**Sheringham Shoal and Dudgeon Offshore Wind Farm Extension Project  
(EN010109): Written Statement**

**The Examining Authority's second written questions and requests for  
information (WQ2)**

## Written Statement by National Highways

Sheet 30

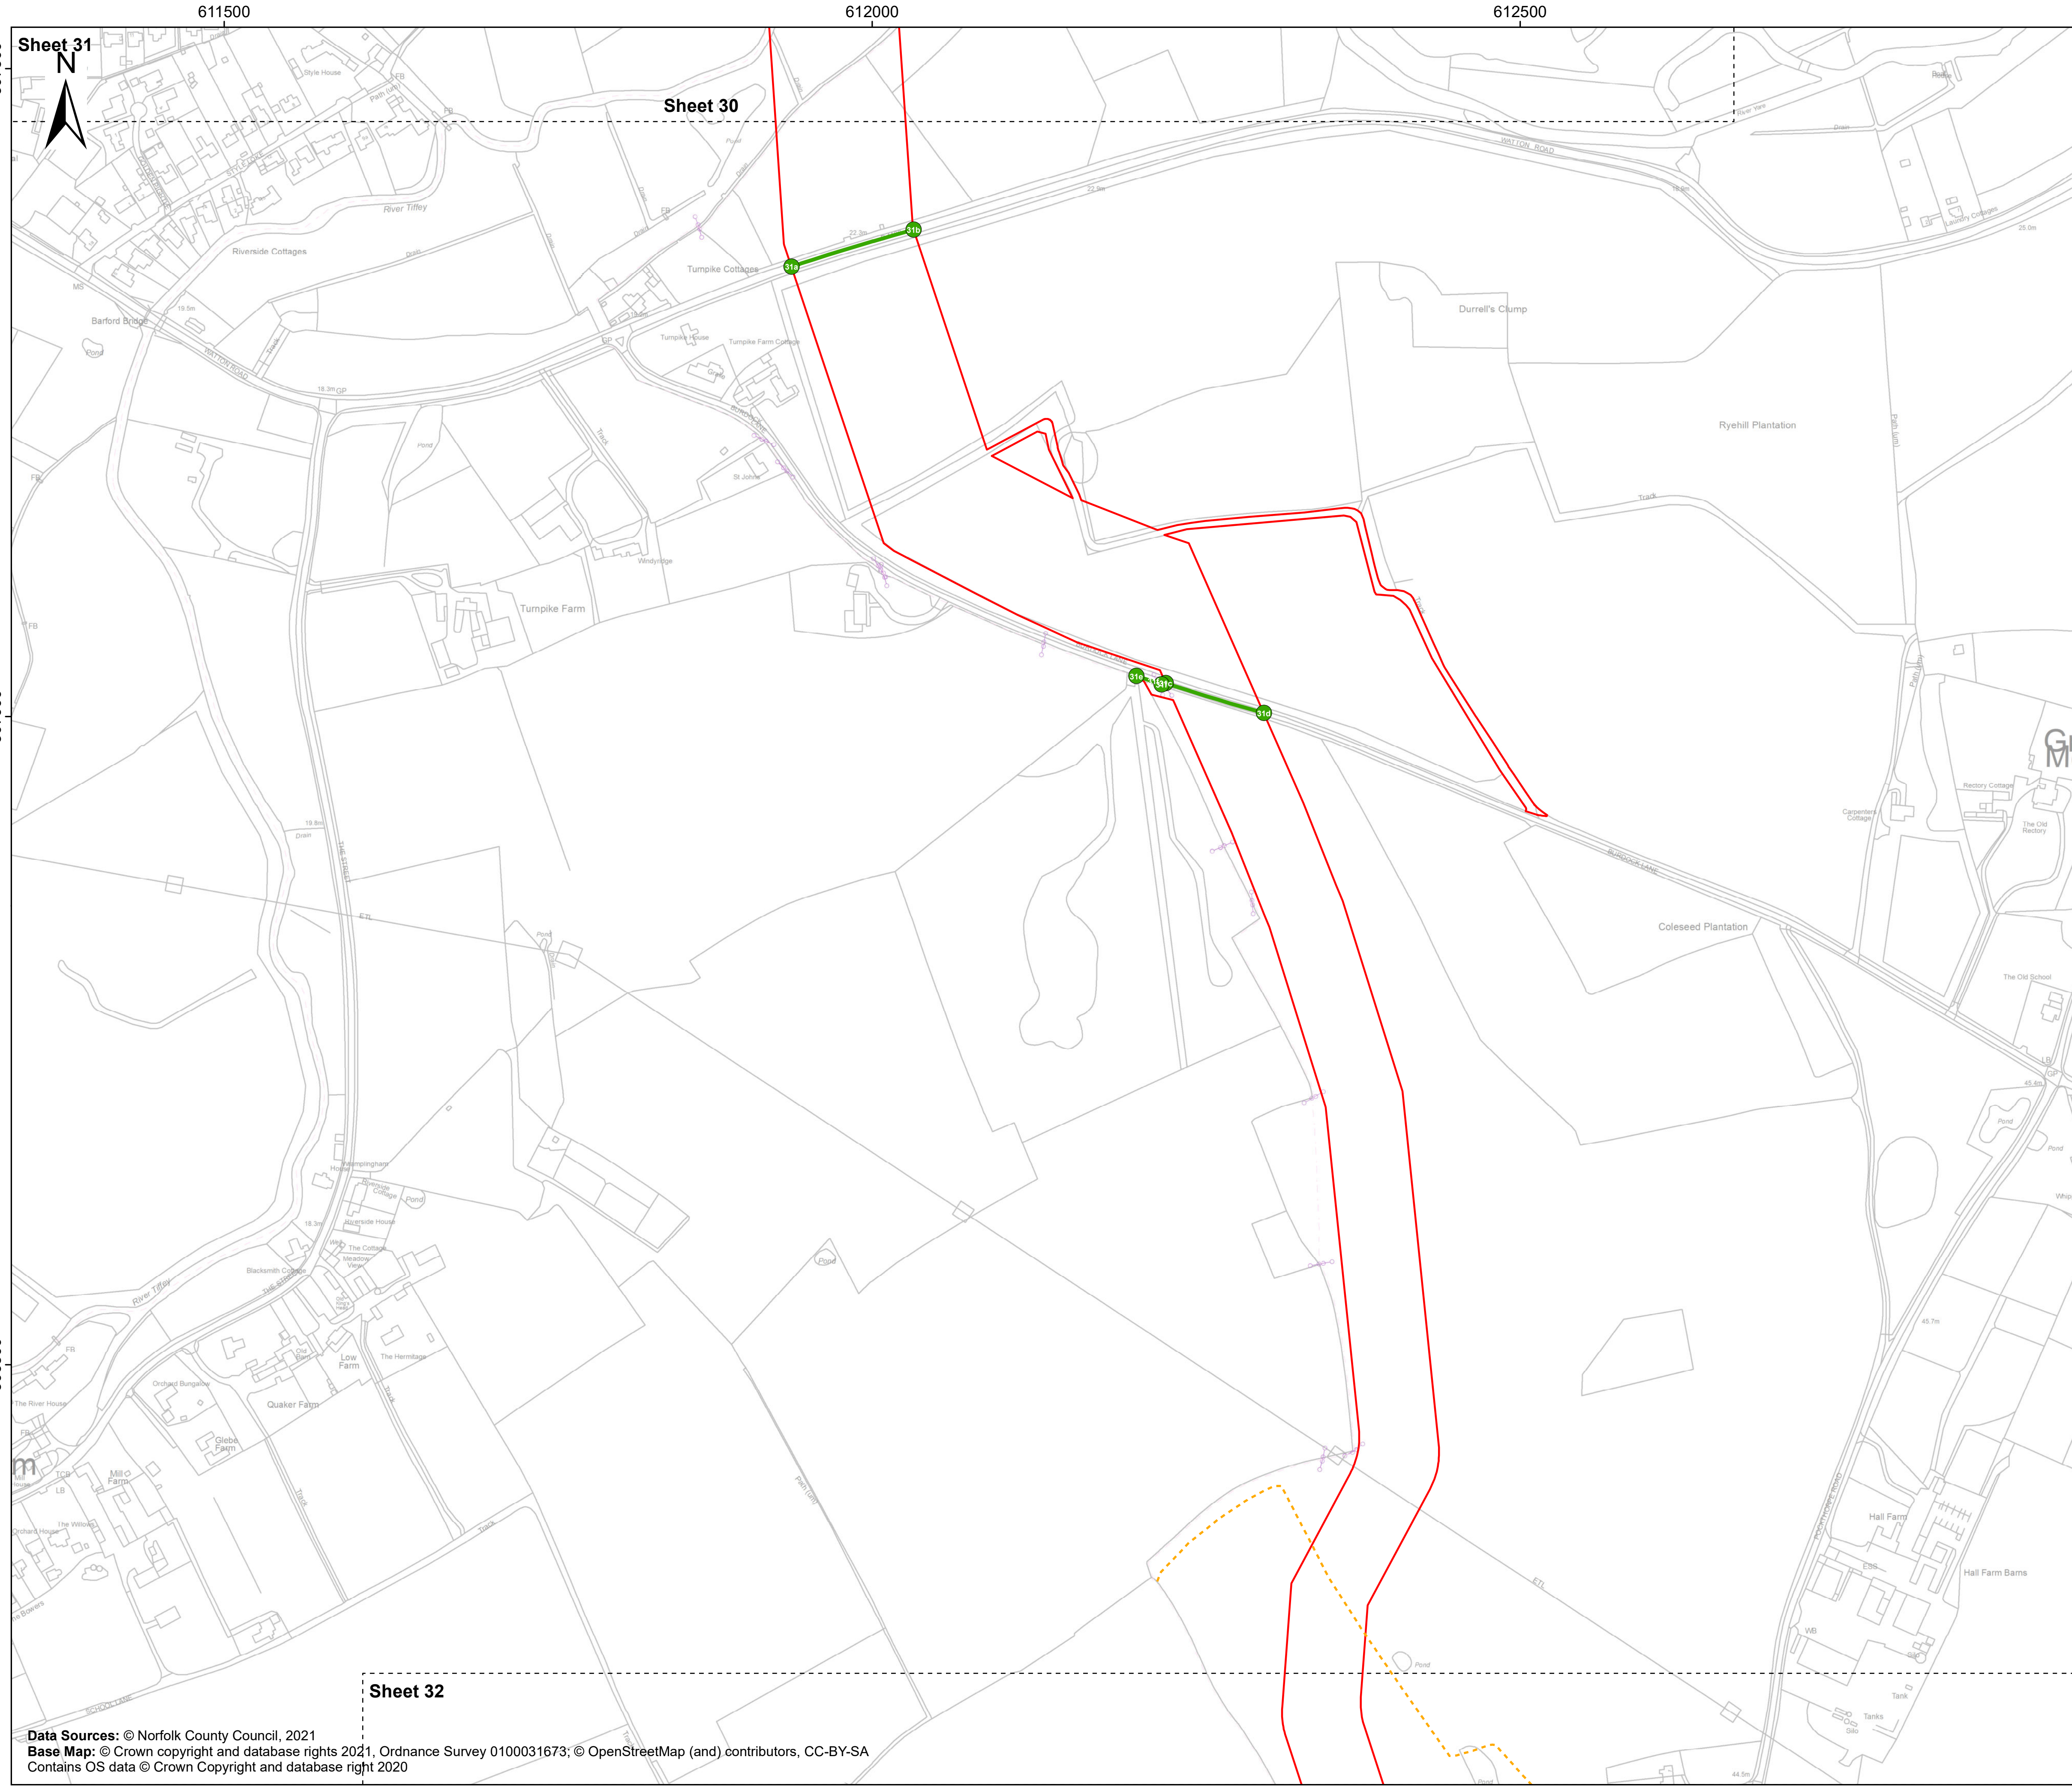
On Sheet 30, the A47 Tuddenham Scheme is not illustrated and as a consequence we have identified possible areas of concern relating to how Equinor's DCO will manage the challenges that may occur when crossing the new A47 Tuddenham Scheme during and post construction. The A47 Tuddenham Scheme received consent in August 2022 under the [A47 North Tuddenham to Easton DCO as Made by the Secretary of State](#), following an Examination period that started in April 2021. National Highways engaged with Equinor during 2020 to raise awareness of the scheme and shared preliminary design information. As Equinor's scheme was still in early development, at a meeting on 15 April 2021 the A47 team updated in the meeting the examination position of the National Highways scheme, as well as landowner and potential launch pit location considerations specific to the Food Enterprise Partnership. The Equinor team updating their current scheme position, the National Highways A47 Project Team invited Equinor to engage with them when they felt necessary to ensure the A47 Tuddenham Scheme was duly reflected in their application.

National Highways acknowledges that several construction access points off the A47 are proposed on Sheet 30 of documents 2.9 Access to Works Plan, Revision D, ([AS-051](#)) and 2.10 Streets (to be temporarily stopped up) Plan, Revision C, ([AS-052](#)).

- Sheringham and Dudgeon Extension Projects DCO Order Limits assume public highway access rights to a new private field access off Taverham Road. This has created two problems based on assumptions not previously explored with the A47 Major Projects Team:

- The access Taverham Road side of that field gate is all part of the adopted public highway, even though the realigned Taverham Road itself and the public cycle track off Taverham Road do not extend along the stub to this field gate. The extent of adopted highway in this location remains to be verified as part of future handover of the side roads and cycle track to Norfolk County Council, so any assumption should have included a precaution that part of the track road side of the gate remained private land.

- Access north of the A47 during construction:
  - As illustrated in Figure E below, once construction commences on the A47 Tuddenham Scheme, Equinor could not use the proposed access points off the existing A47 to access their work area between the A47 and River Tud.
  - However, these access points will be removed at the start of the A47 Tuddenham construction period, while the alternative access from Taverham Road will not be available for use until nearer the end of the A47 Tuddenham construction period – a period of approximately 2 years.

- Therefore, National Highways recommends Equinor considers the implications to their construction programme of a 2 year period of no access to this part of their scheme or if access from Church Lane in the east is required to mitigate the risk.
